Ref: Planning Application 2025/62/91880/E

Erection of single storey rear extension and associated alterations (within a Conservation Area).

14 Manor Road, Farnley Tyas, Huddersfield, HD4 6UL

Proposed Block Plan

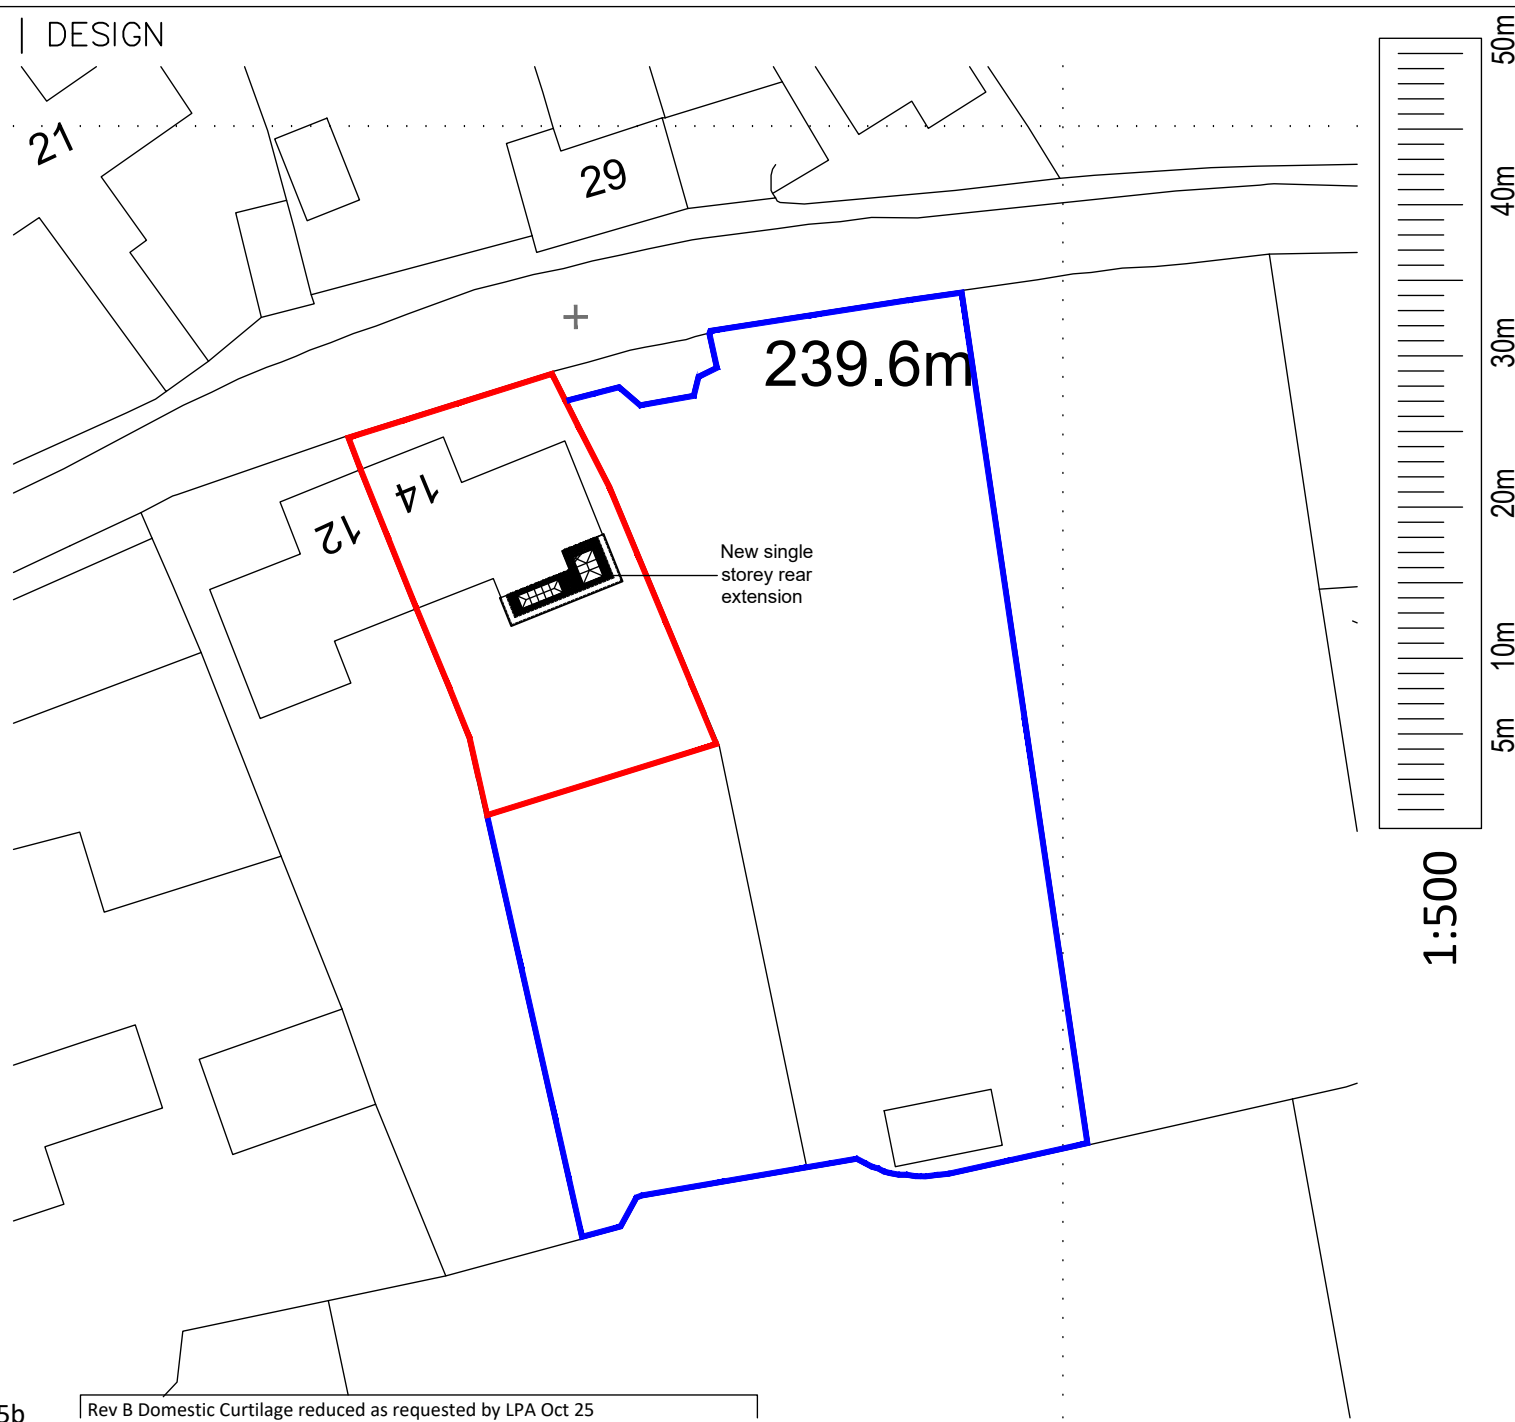
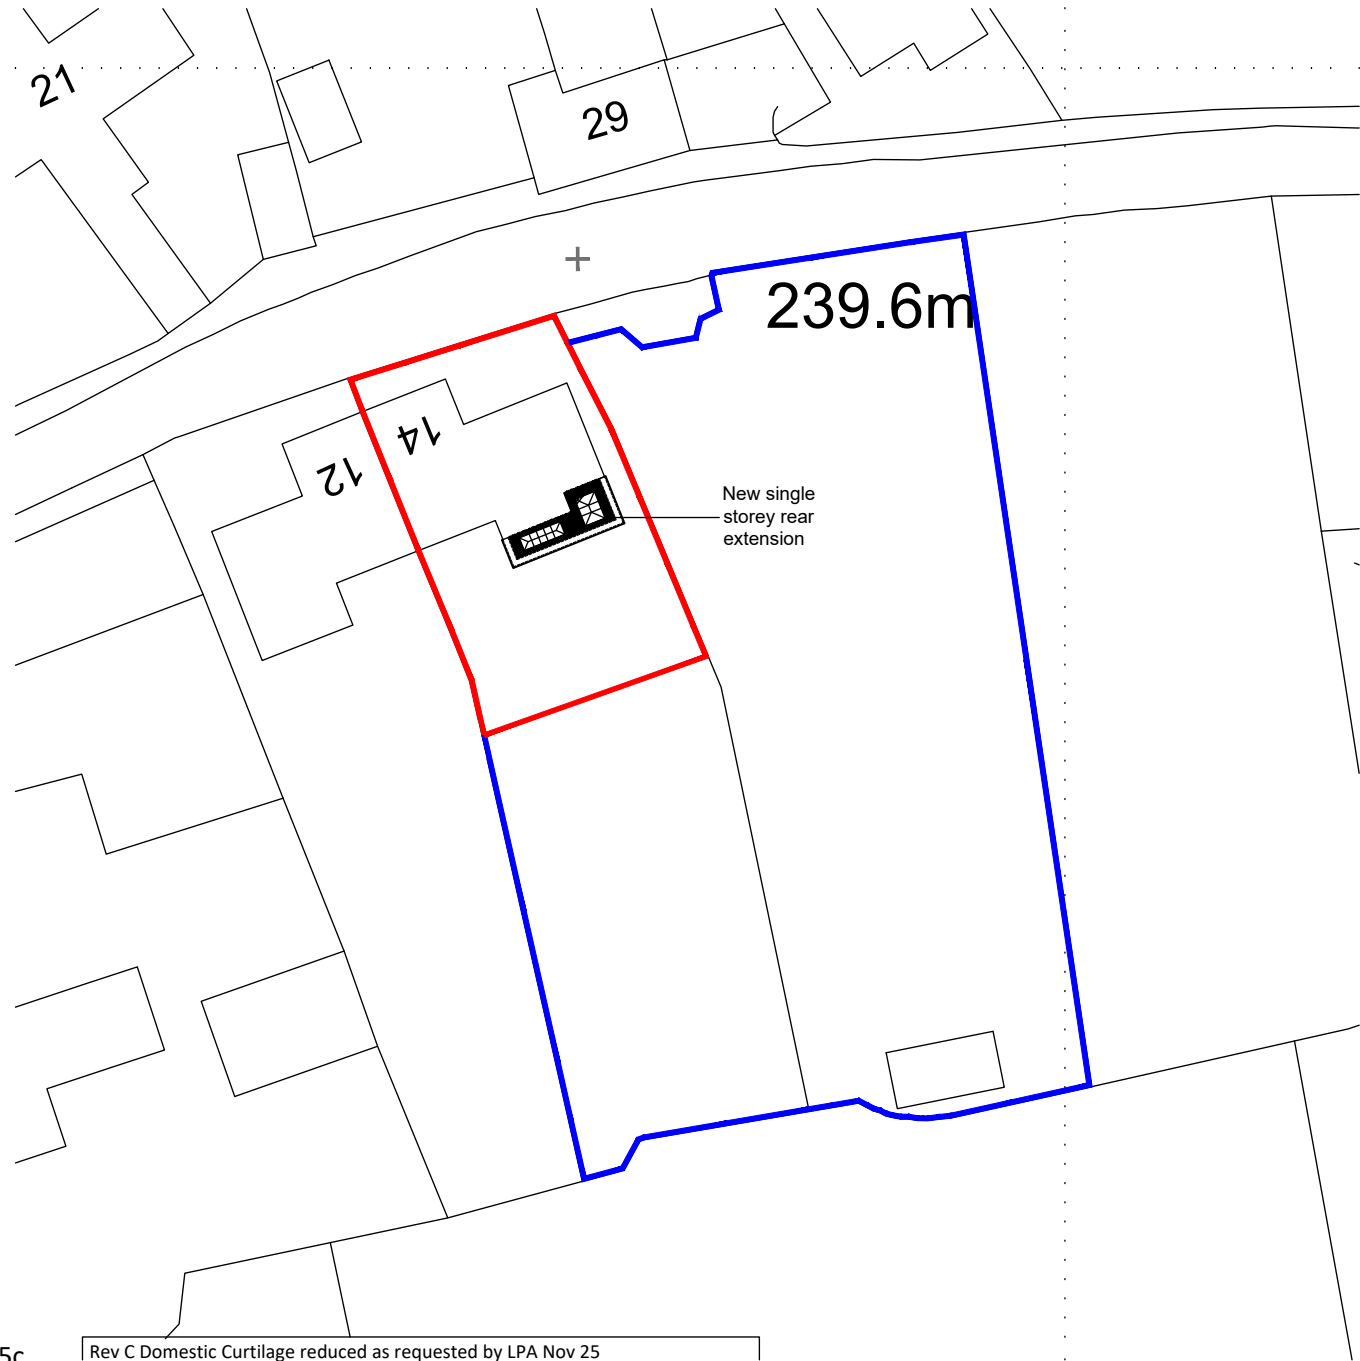
1. The site location plan (drawing No: 25/1196/01) and the block plan (drawing No: 25/1196/05) both show the red line dwelling curtilage of No 14 Manor Road extending the full extent of the adjacent paddock.

This is incorrect as it encloses an area of the original paddock which has never been granted a change of use.

- 2 Planning Application 2016/93524 dated 16th October 2016 granted permission for a change of use to extend the existing curtilage of 14 Manor Road approximately 12M into the paddock behind the dwelling. This was approved on 03-Feb-2017.

- 3 I am not aware of any further planning applications having been submitted in connection with this issue and the current application does not include for a change of use of this section of the paddock.
